*Our ref: 09/170-02*

21 March 2013

**RE: Orica Southlands Remediation & Warehouse Development Project  
Modification Application (MP 06\_0191 Mod 1)**

Southlands Industrial Estate **Figure D9a**
Final Development Scenario 50% AEP flood level difference map

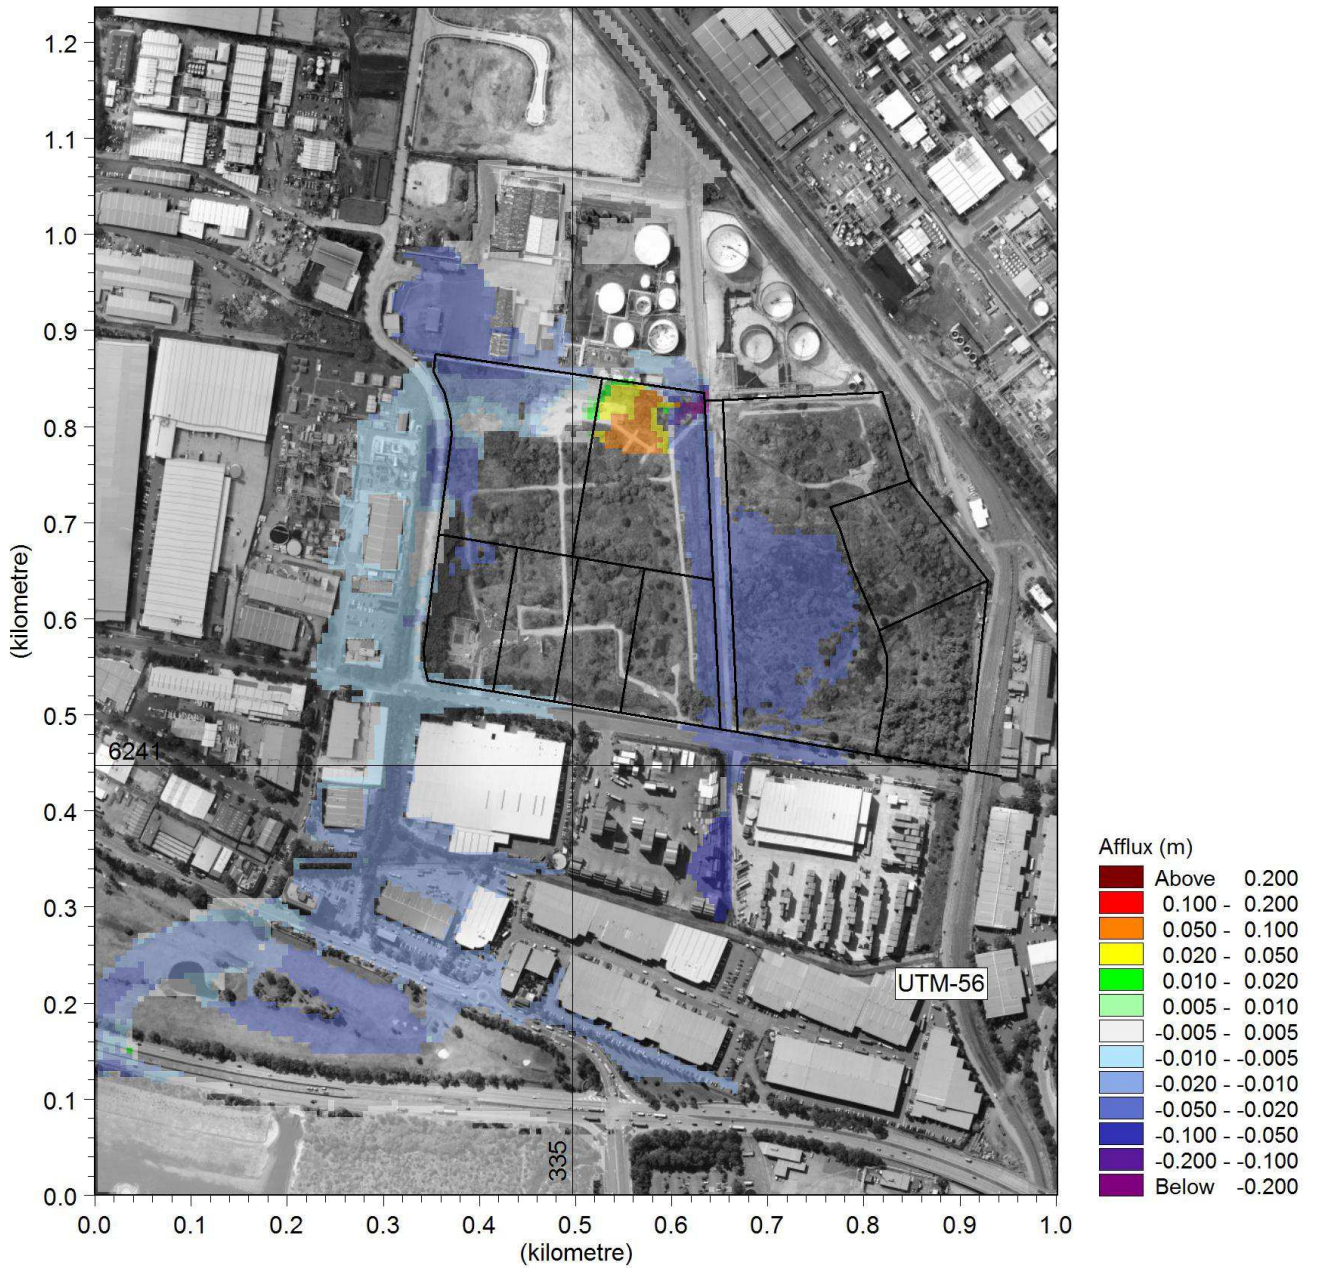
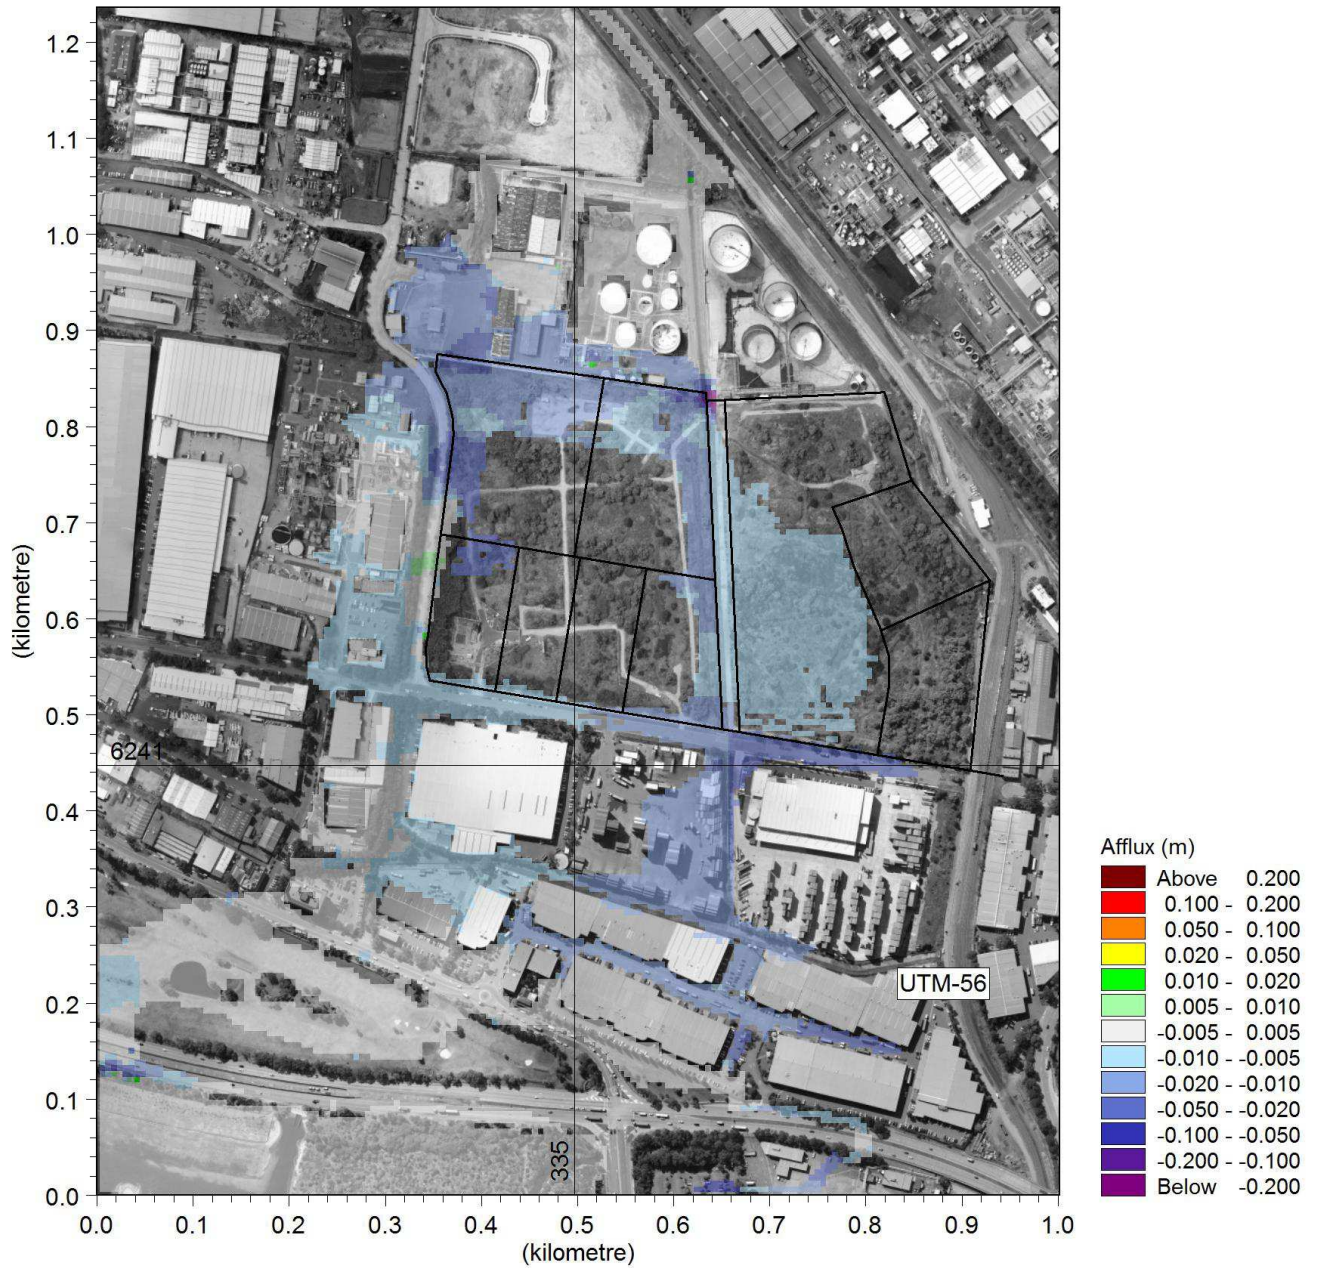
- **Flood Storage Basin** - To fully understand the impact of the altered flood basin and proposed drainage systems, Council requests the following information be provided:
  1. Plans showing concept design of proposed hydraulic outlet from Stage 1 basin within Springvale Drain upstream of McPherson Street.
  2. Longitudinal section and Cross-section plans of the northern channel and Stage 1 flood storage basin.
  3. Flood extent maps showing modified "Water Surface Elevation" for 2 year, 10 year and 100 year ARI events due to proposed changes of the flood storage basin.
